Address: 21 Steep Riding Holmfirth HD9 7BH

Application number: 2020/91919	
What is the application for?:	Demolition of existing supermarket and erection of block of 6 flats with associa
Address of the site or building:	The Co Operative Food, 19, Northgate, Almondbury, Huddersfield, HD5 8RX
Postcode:	M60 0AG

PROPOSED ELEVATIONS C & D

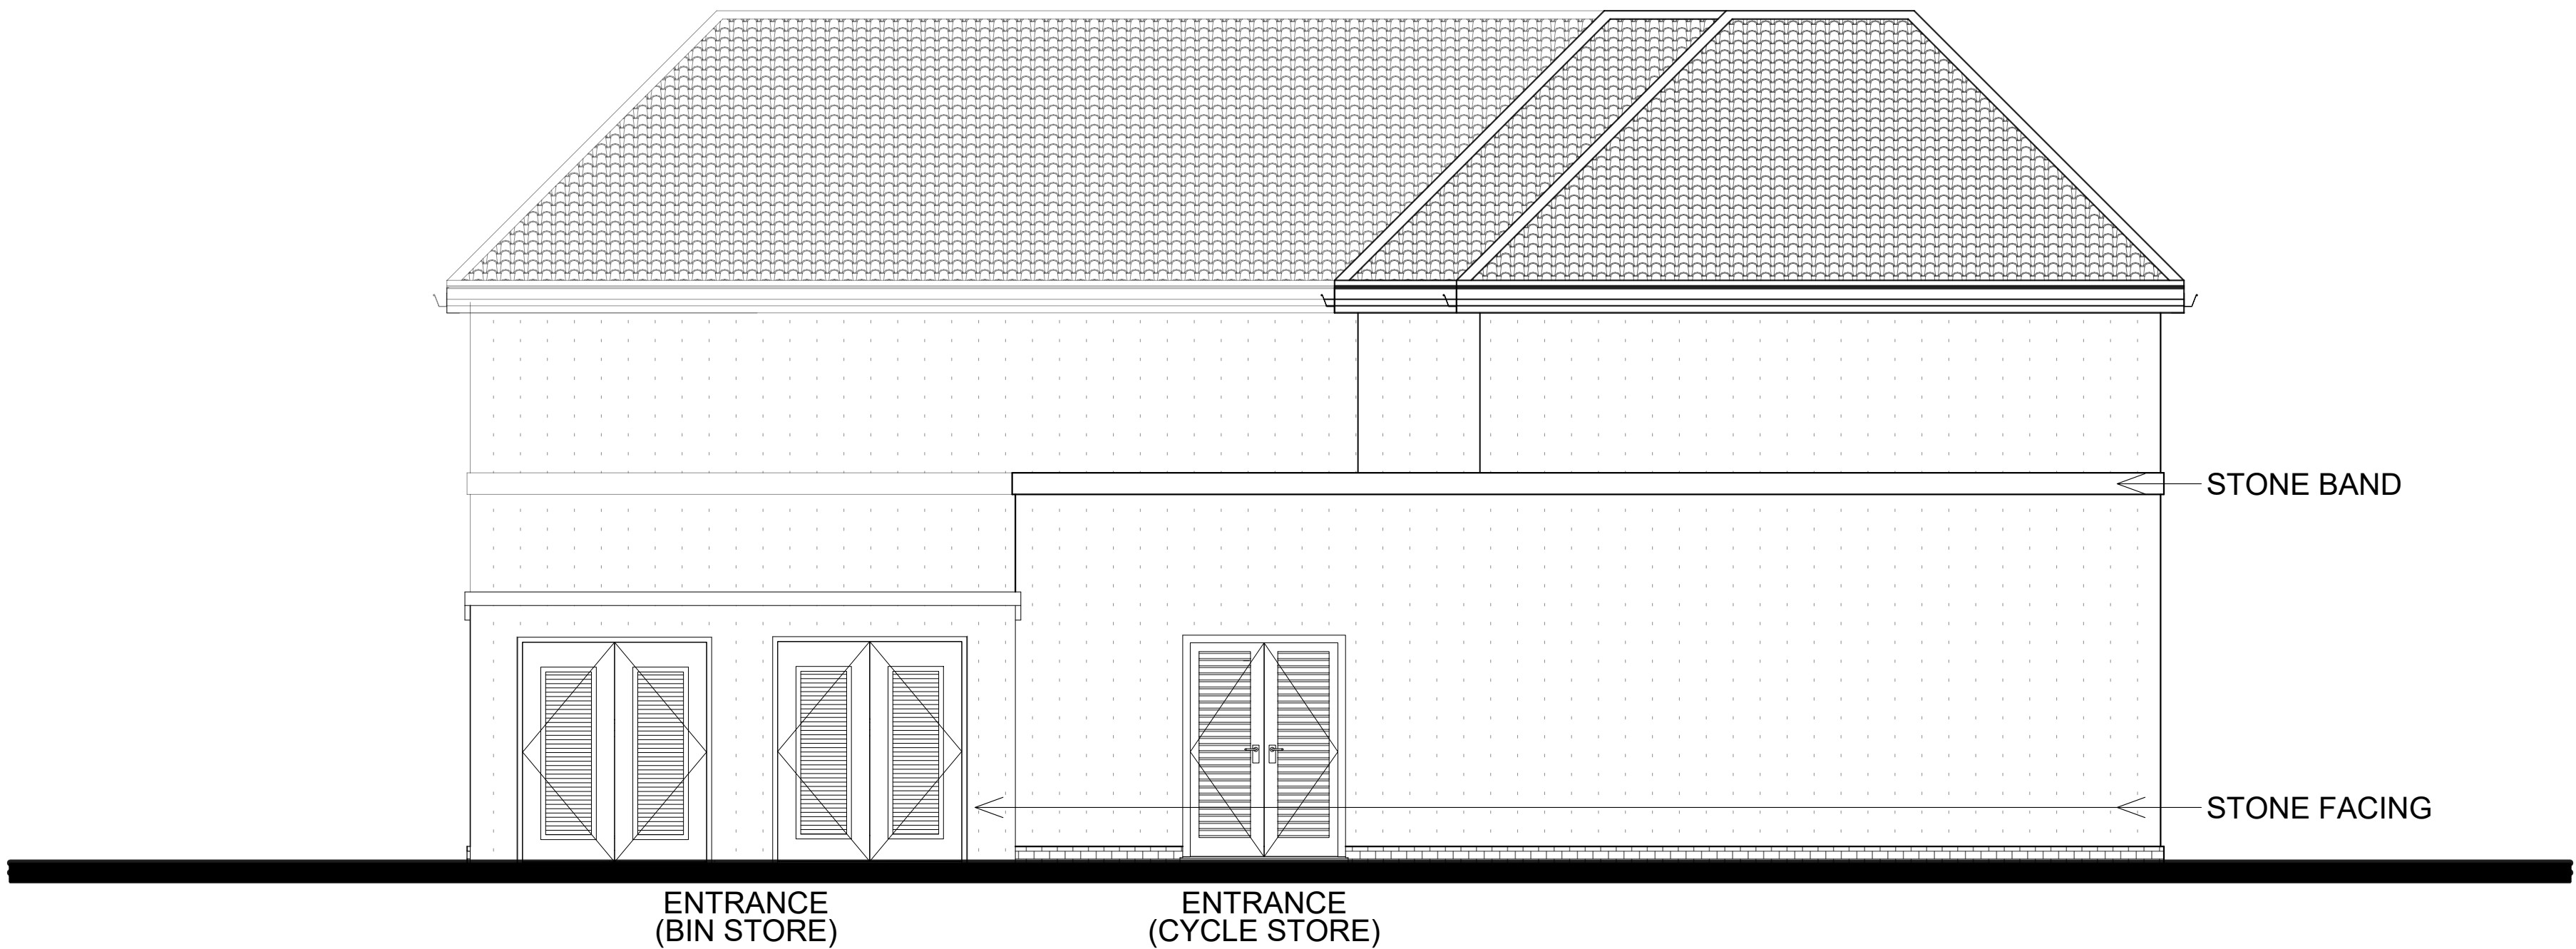
Type of comment: An objection	
Do you wish your comments to be published on the website anonymously?	No
<p>Comments made on behalf of Huddersfield Civic Society.</p> <p>As stated at the time of the original submission, whilst there is no doubt that the existing supermarket building is a negative element within the townscape of this important and historic Conservation Area, the proposal to replace it considered to be unacceptable.</p> <ul style="list-style-type: none">- The scale of the development, comprising one large structure, is over-intensification of the site and is out of character with surrounding properties within the conservation area.- The introduction of flat roofs to reduce the impact of the size of the development is entirely inconsistent with roofs within the locality and surrounding listed buildings.- The development should be constructed of coursed York stone to all elevations.- The over-intensive use of the site allows no room for green space to alleviate the impact of the structure, which has a negative impact on adjacent properties and their amenities.- The police security proposal is completely inappropriate, making no allowance for the conservation status of the location. The fencing recommendations would prevent appropriate sight lines for the proposed new Co-op site access and the site access.- It is felt any development should recognise the traditional street frontage, with dwellings fronting on to the pavement with the possible creation of a secure archway access to rear parking for a reduced number of dwellings.- The D&A Statement is misleading and reject the claim that 'The proposal has been designed to fit seamlessly within the surrounding area.'
